Minor Subdivision Responses to Comments

FIGURES 3 & 4

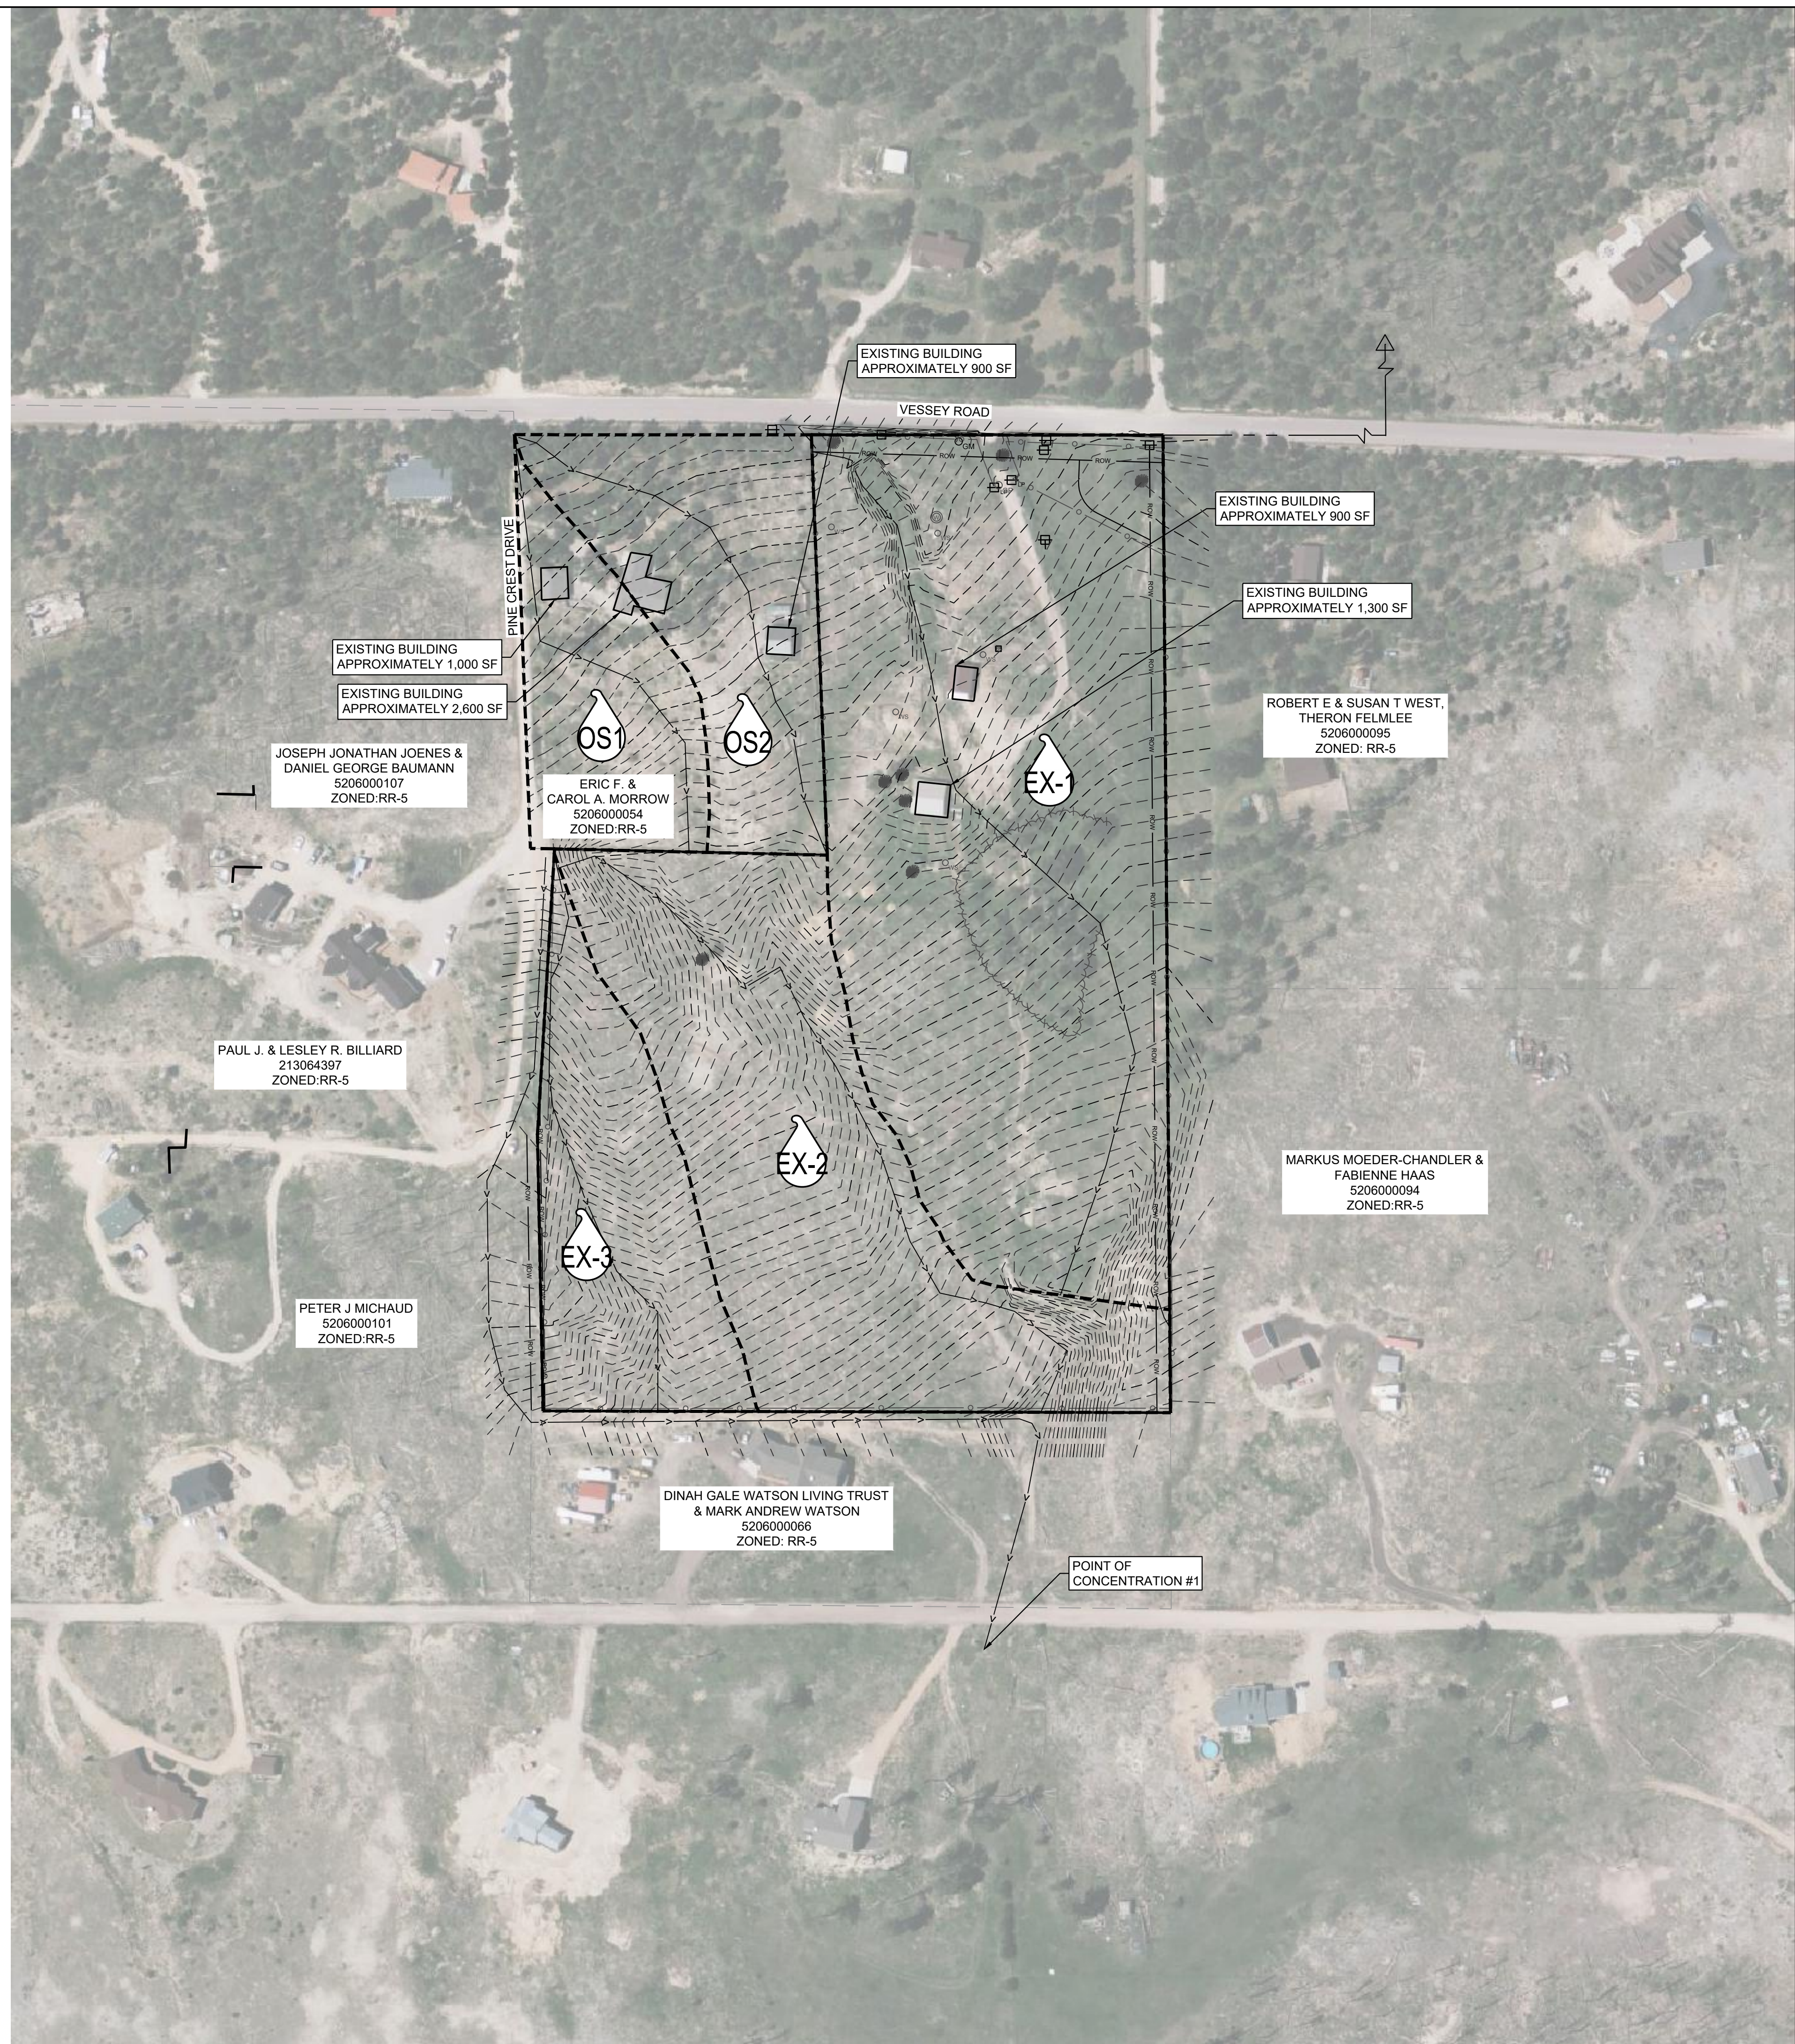
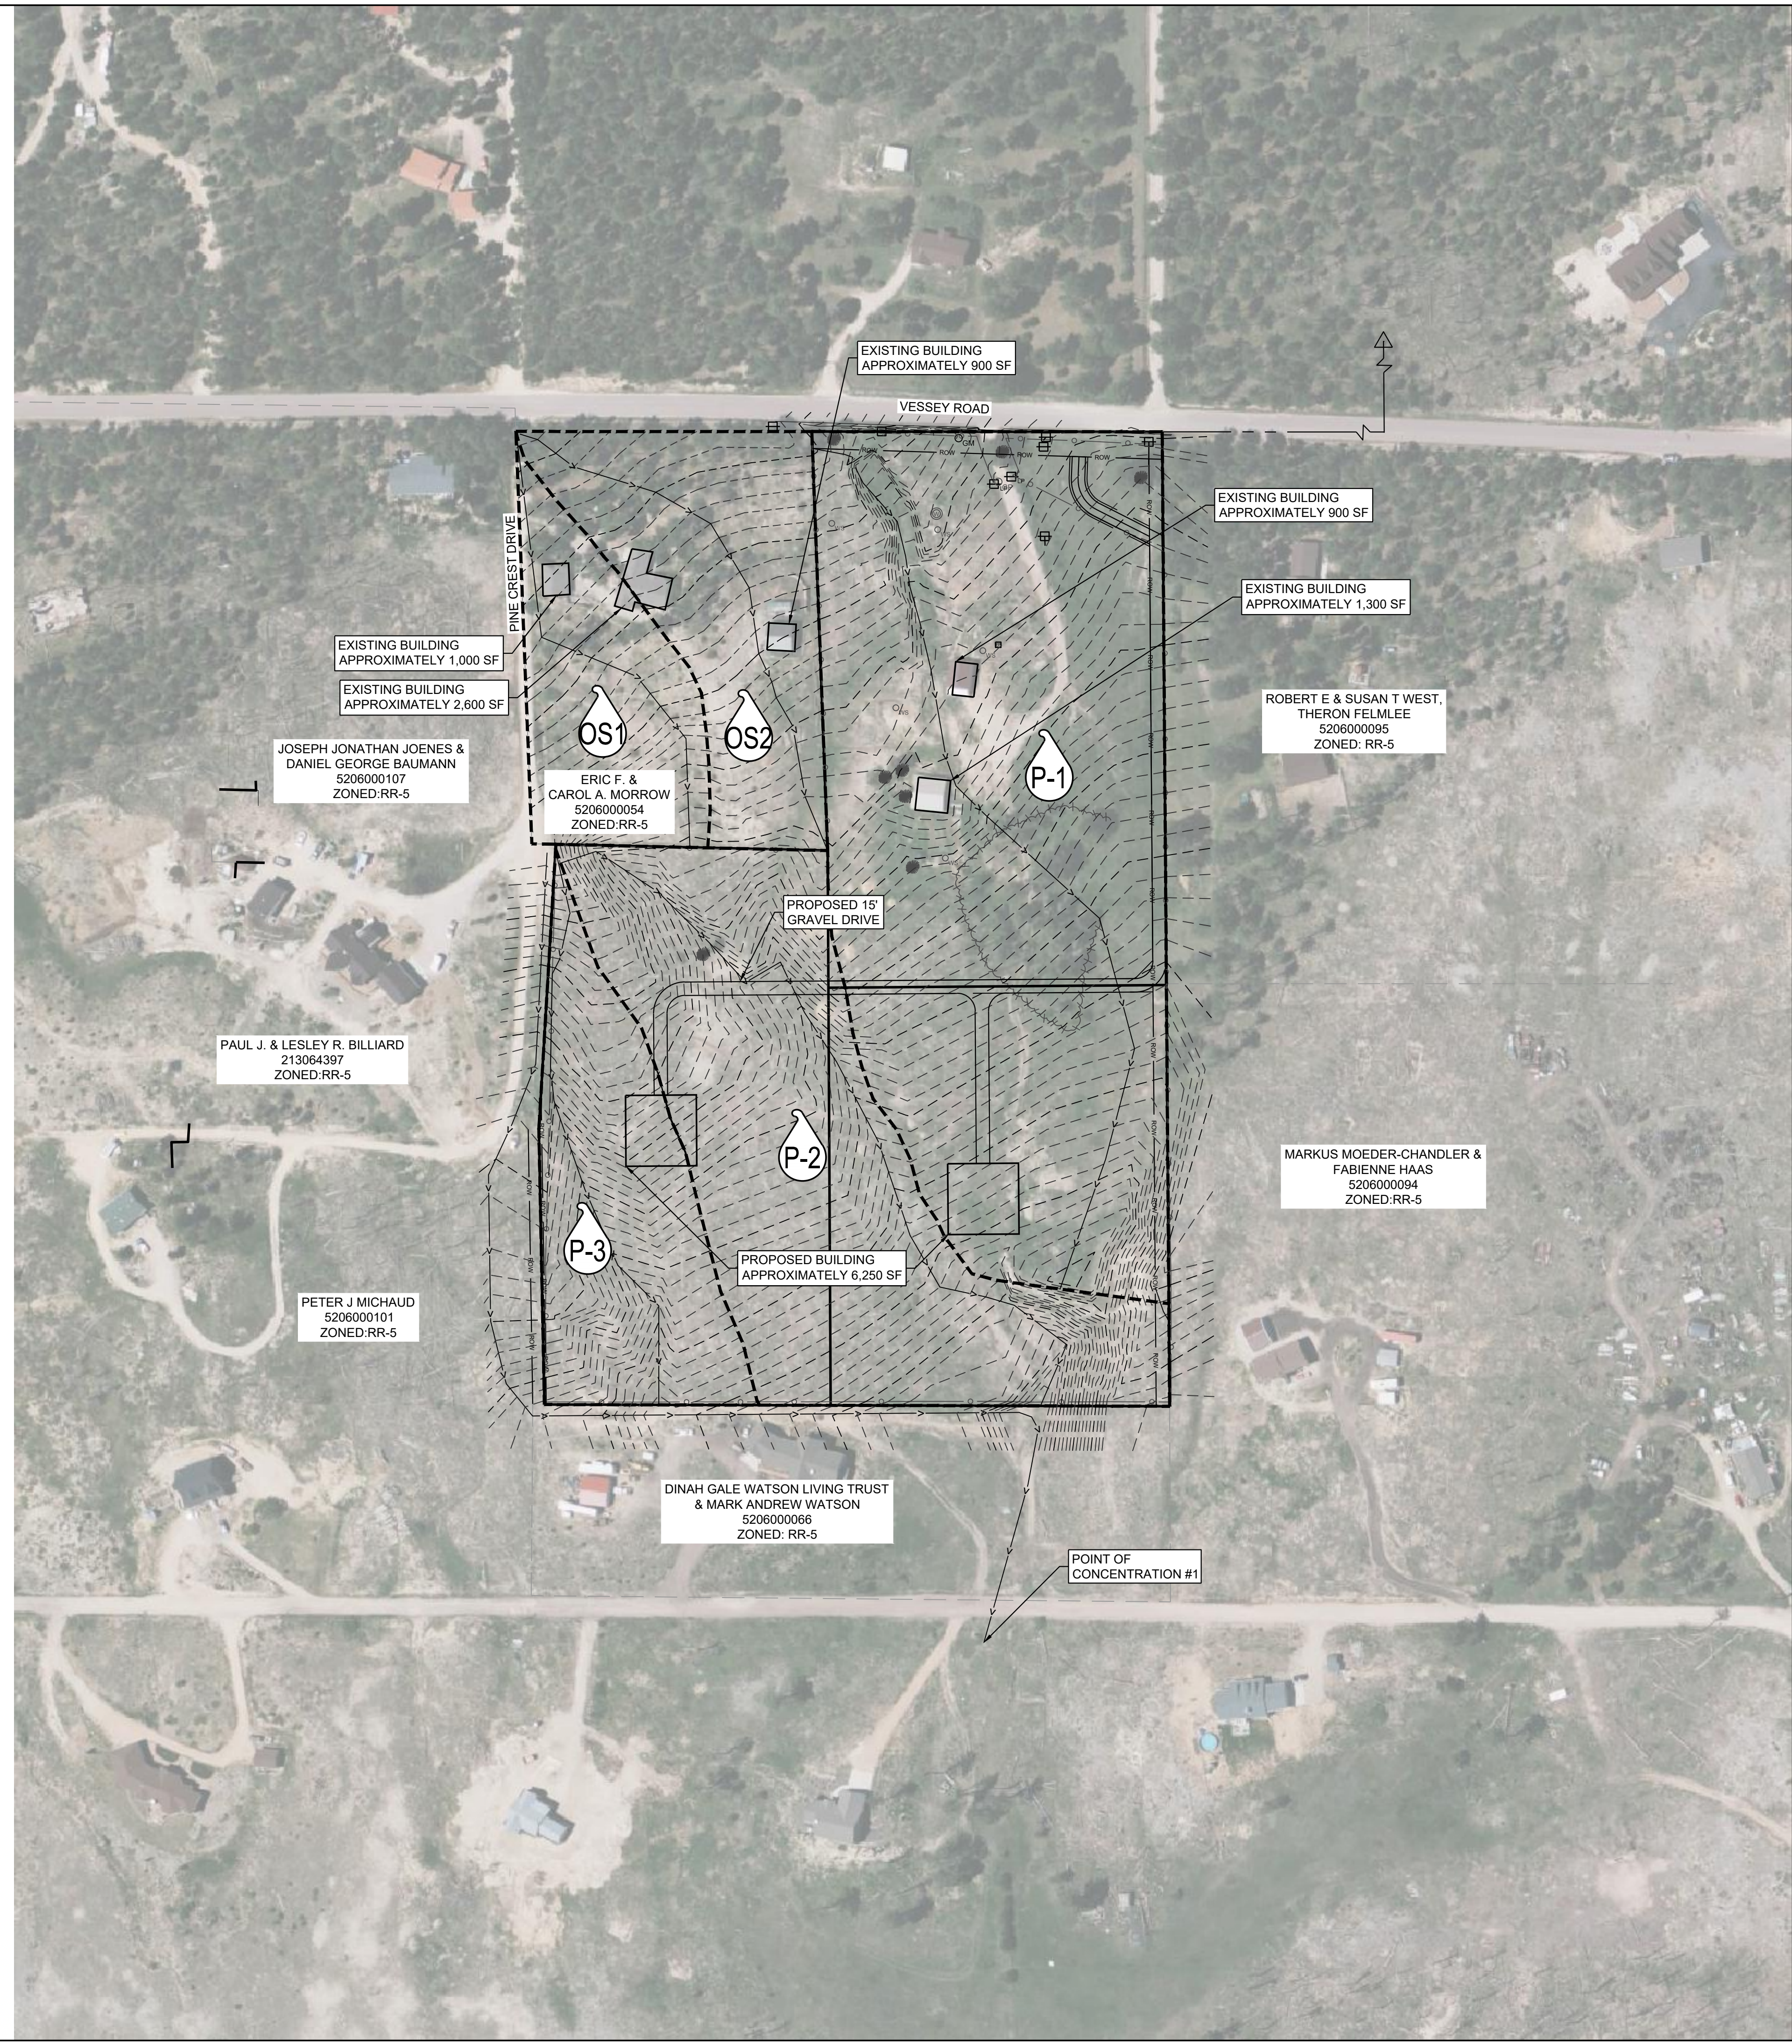
- Coordinate with the State Dam Engineer regarding what appears to be a stock pond in the property and provide a summary of the coordination in the drainage report. **Discussion added to report under the discussion for existing drainage area 1.**
